2003-0261

498 Island Ave. PEAKS ISLAND

RE: 498 Island Avenue, Peaks Island
(ID# 2003-0261, CBL#090J004)

Thank you for your application for a single-family house at 498 Island Avenue. Upon review, planning department has the following comments:

BOUNDARY AND TOPOGRAPHIC SURVEY
ON
ISLAND AVENUE, PEAKS ISLAND, PORTLAND, MAINE
MADE FOR
NANCY WRIGHT

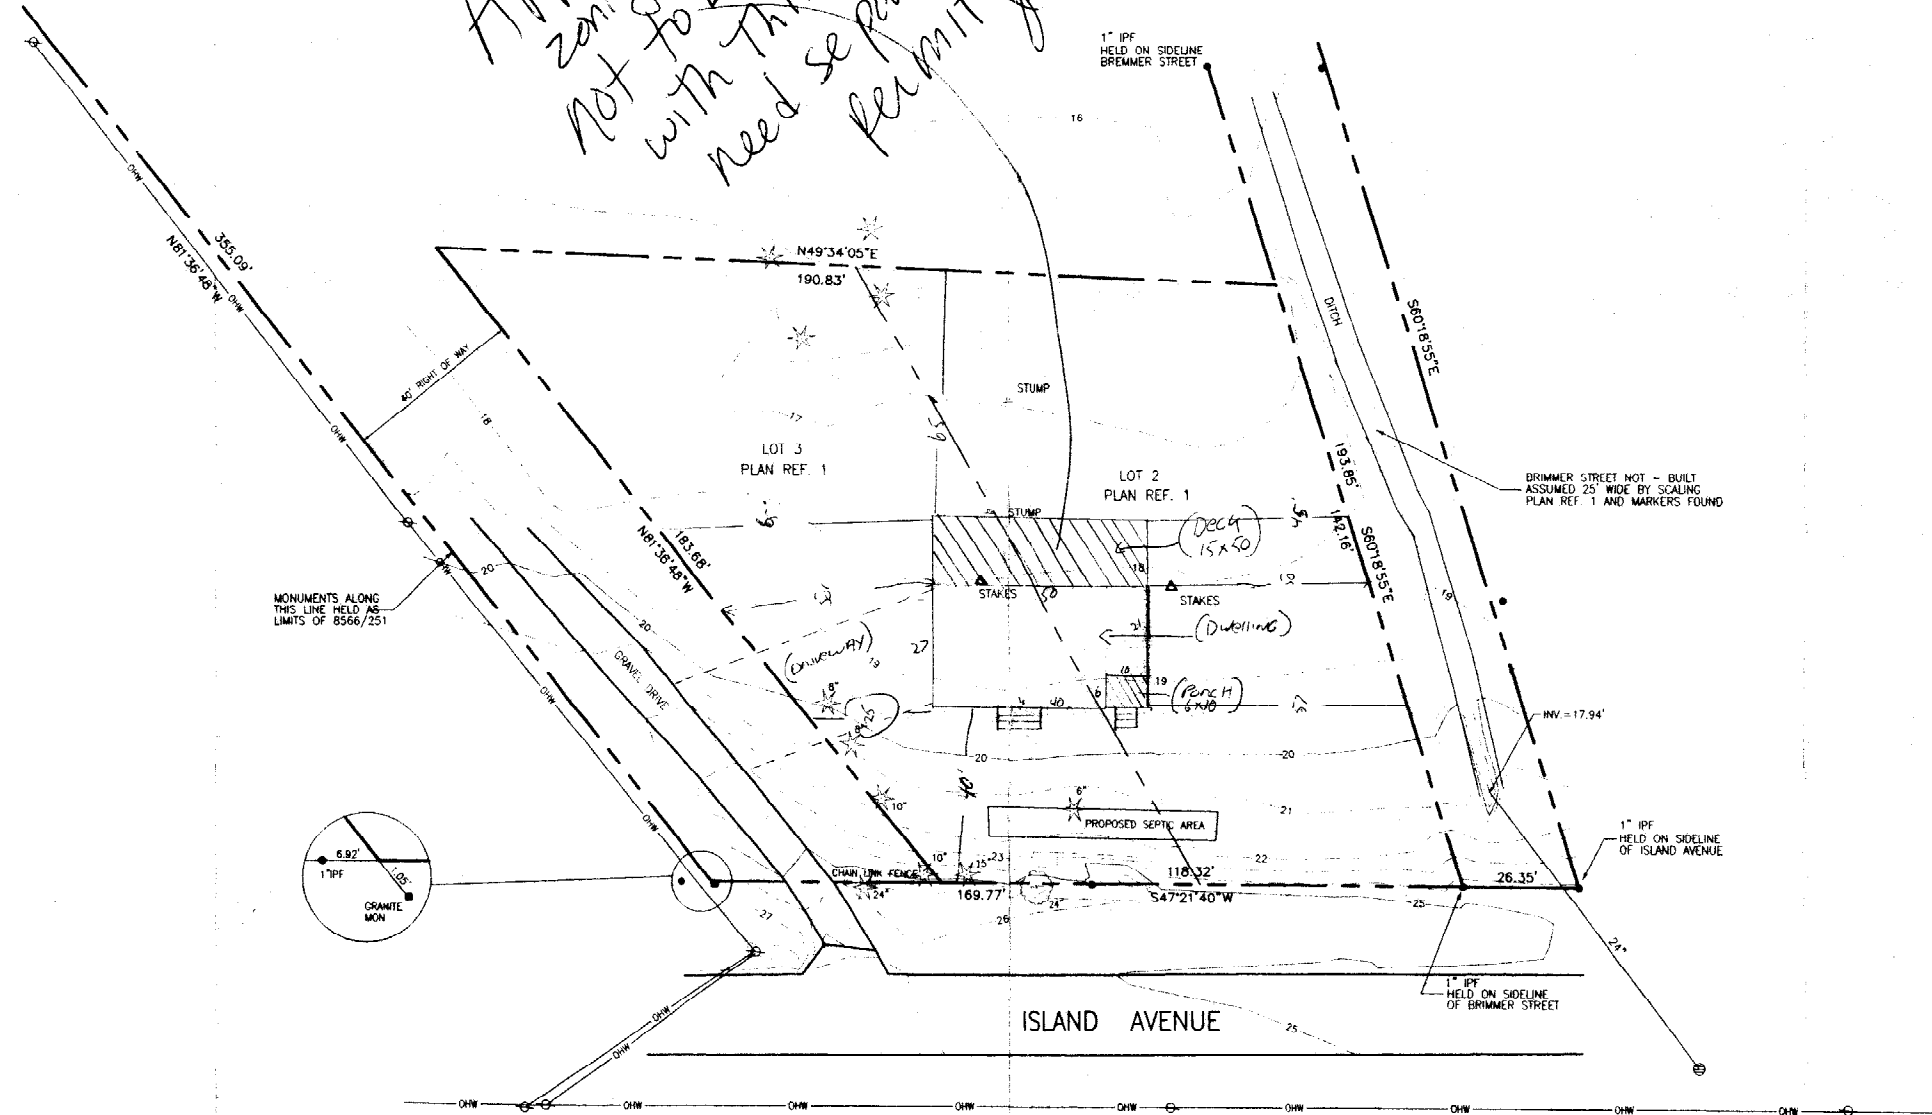
1. Please add any/all proposed changes in grading. Also, add the sill or finish floor elevation.
2. Please add 2 proposed street trees along the Island Avenue frontage of the lot, as required by ordinance for single-family development.
3. Please show the proposed water service/well that will service the new building.
4. Please note the distance of the nearest fire hydrant on the site plan.
